Final Report of Special Inspections

Project: *Addition and Renovation*

Location: *503 Woodfords Street, Portland, ME*

JOB NAME: 503 Woodford Street - Shalom House
JOB NO.: 13005
DATE OF VISIT: Jul 01, 2013
TIME: 10:00 A.M.
CLIENT: Shalom House
OBSERVERS: David Tetreault, SDC

4 ROOF FRAMING PLAN
1/4" = 1'-0"
N

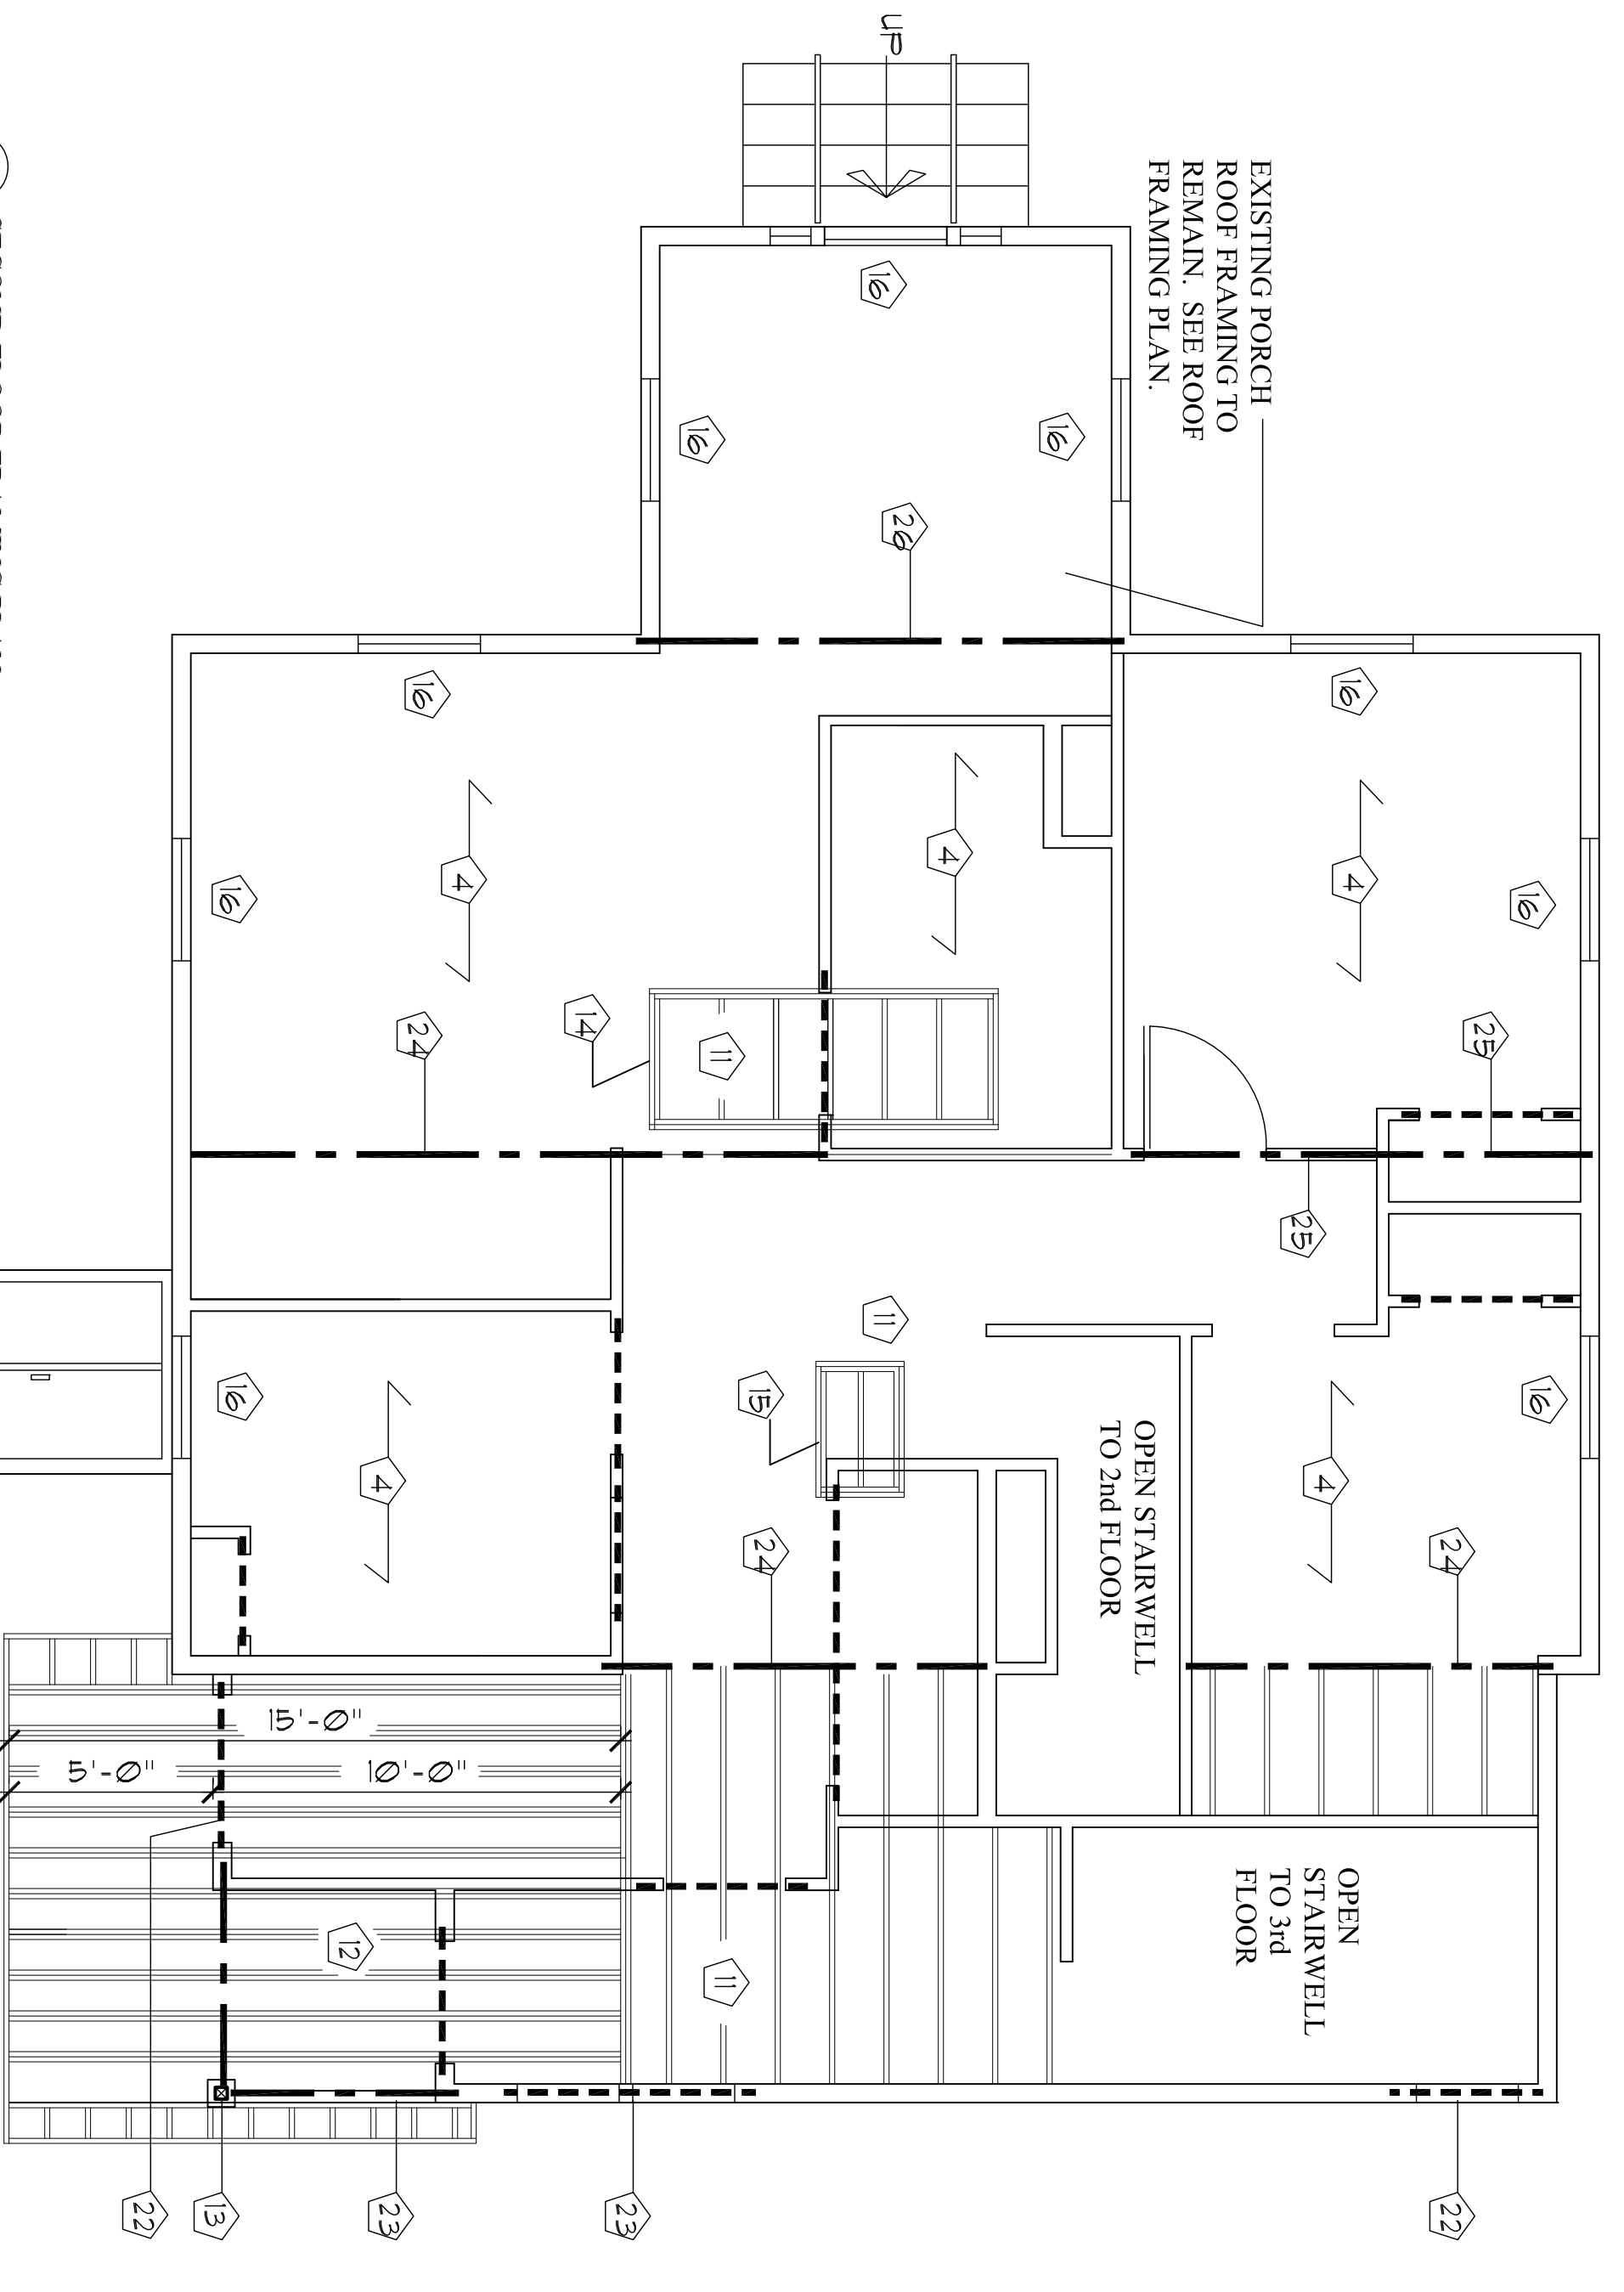
The east and west edges of the second floor dormers are supported by walls that are to be removed. There is a single 2x6 rafter above both of the existing walls. Both of these rafters must be reinforced with (2)1¼"x5½" LVLs.

2 SECOND FLOOR FRAMING PLAN
1/4" = 1'-0"
N

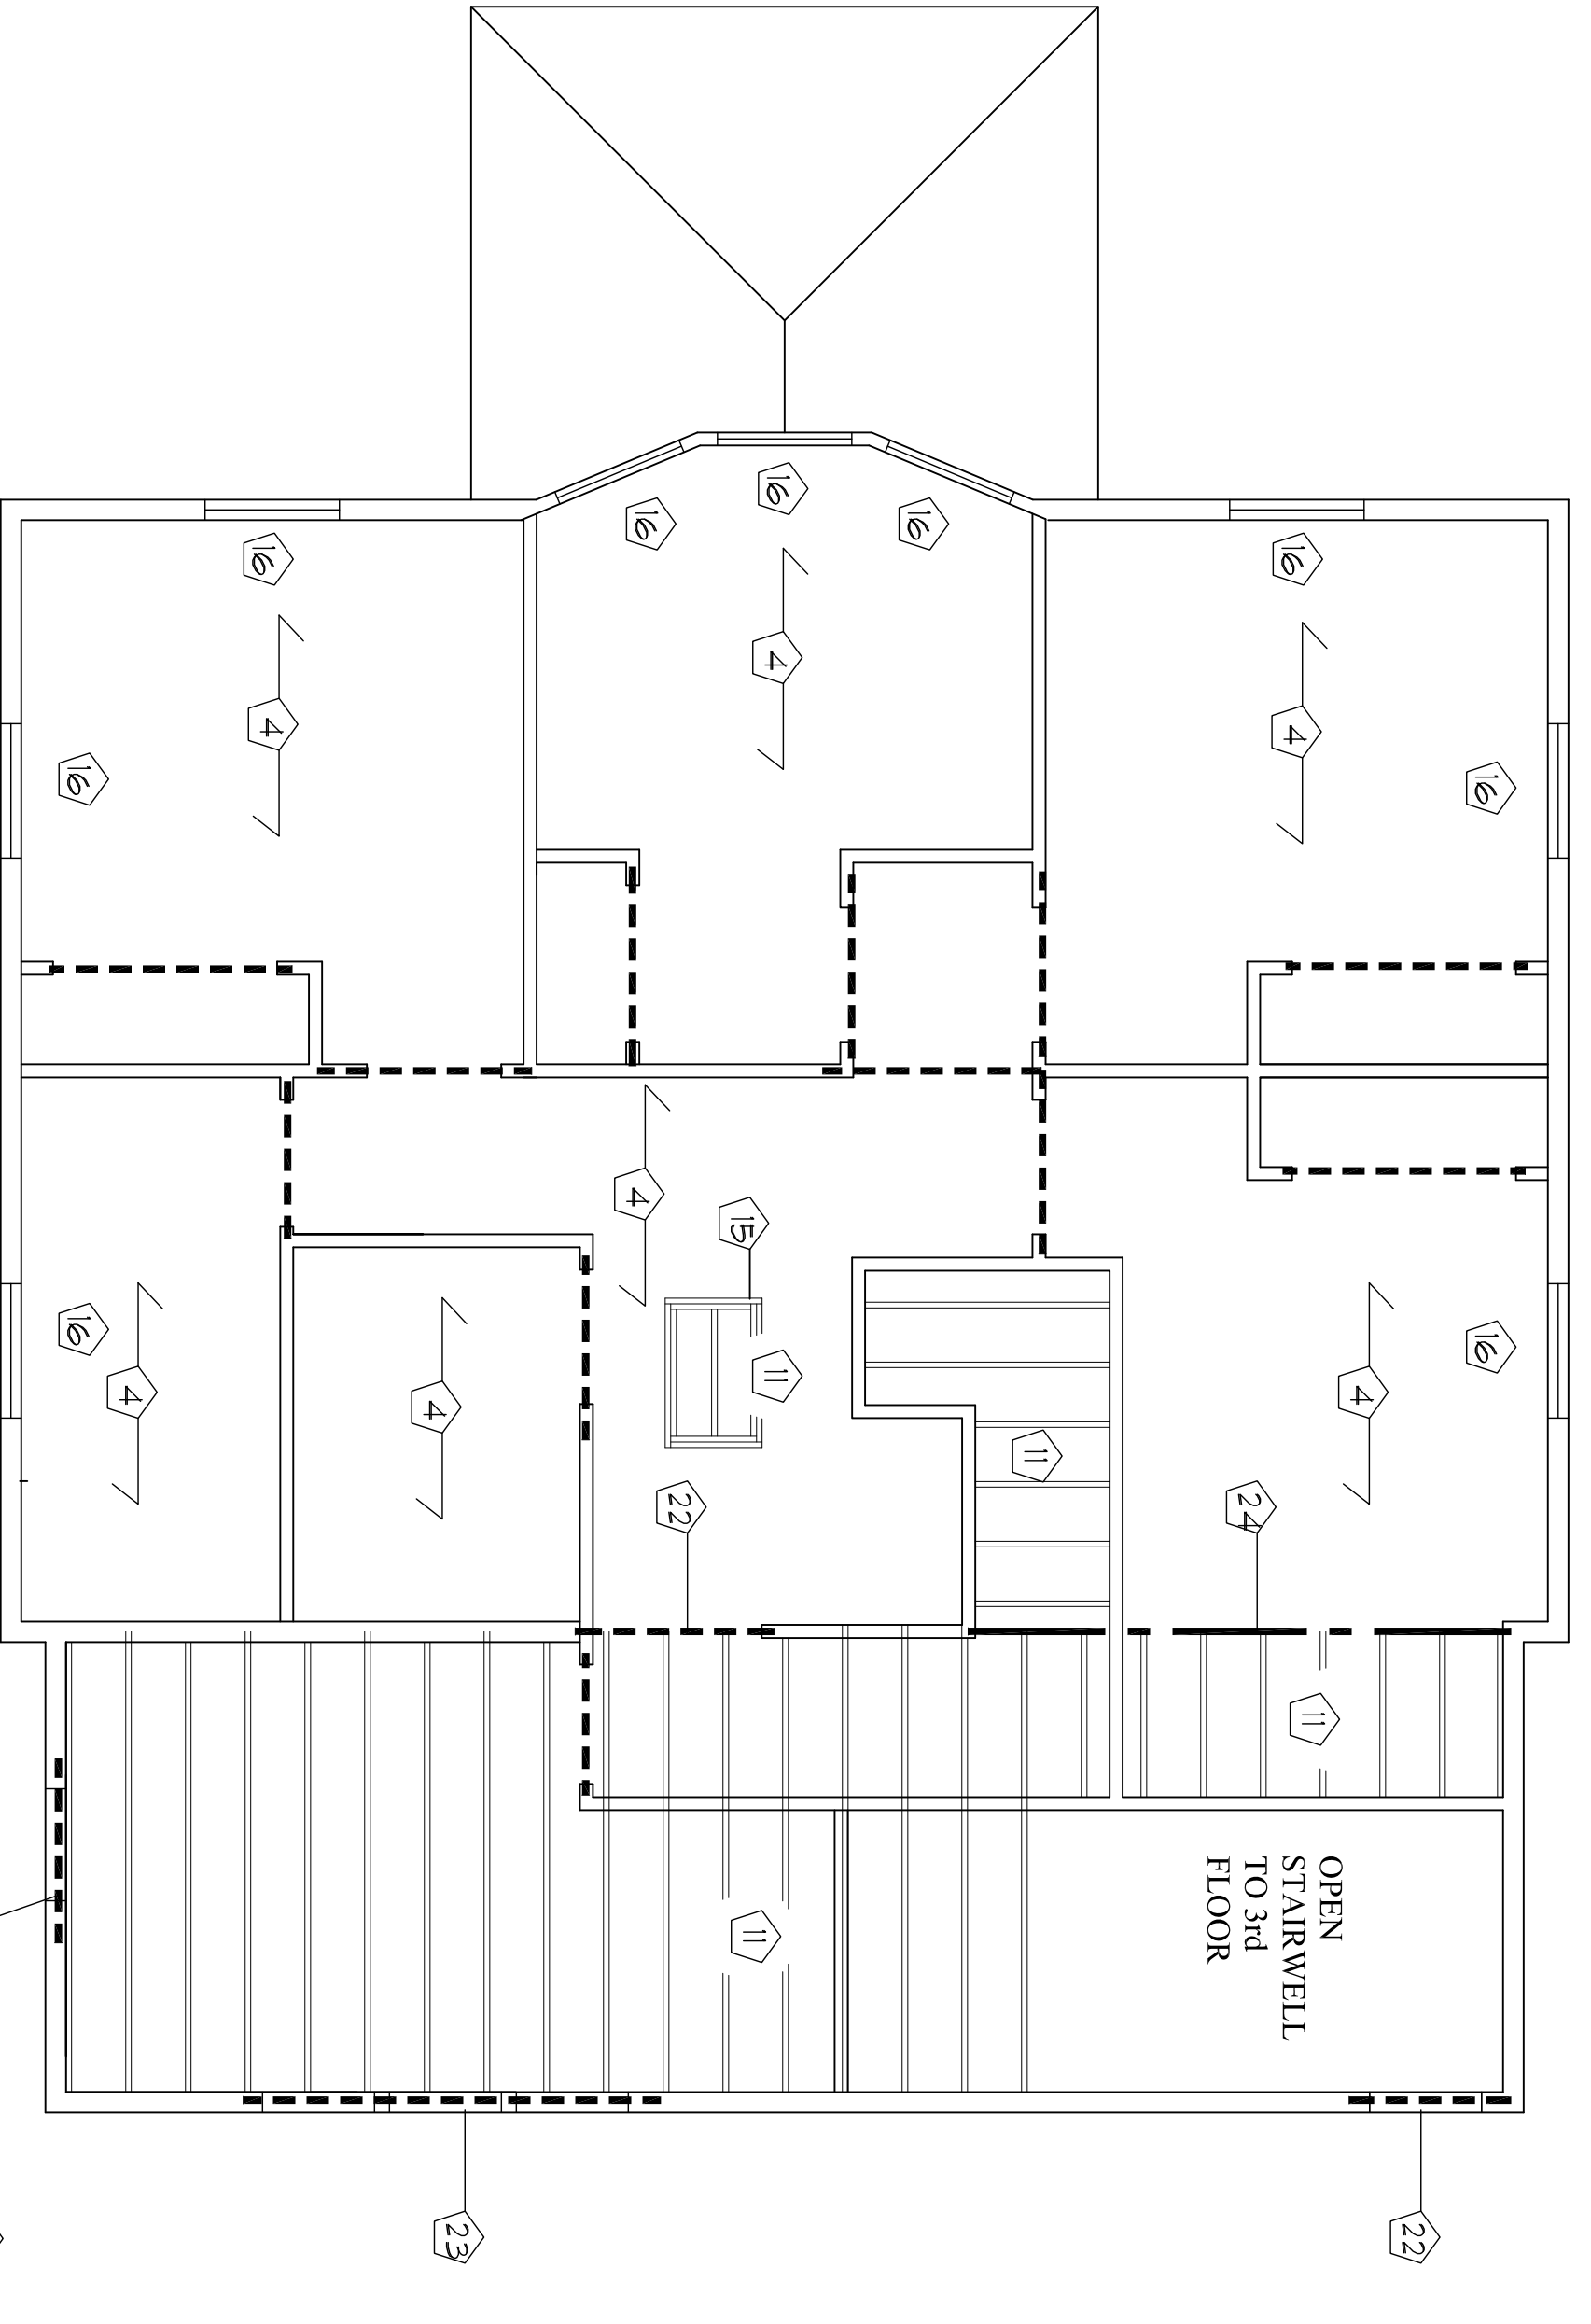
Several floor joists have been cut for installation of plumbing or other reasons. All floor joists that have been cutoff, notched deeper than 1" at the top or bottom or have holes with diameter larger than 3" must be reinforced with a new 2x8. Joists that have been cutoff are to have full span reinforcement. Joists that have been notched or penetrated with a hole shall be reinforced 36" beyond the compromised location. Fasten the reinforcement section to the existing joist with (3) 10d nails spaced at 12".

Second floor joists at both ends of the existing interior stair opening must be reinforced with (2) 2x8. Fasten the reinforcement joist to the existing joist as noted above.

The existing (3)2x10 second floor beam east of the existing interior stair is acceptable. A new beam in that location is not required.

The new (3)1¼"x11¼" LVL scheduled to be installed at the second floor in the south exterior wall must be shifted south to align with the south face of the exterior wall above.
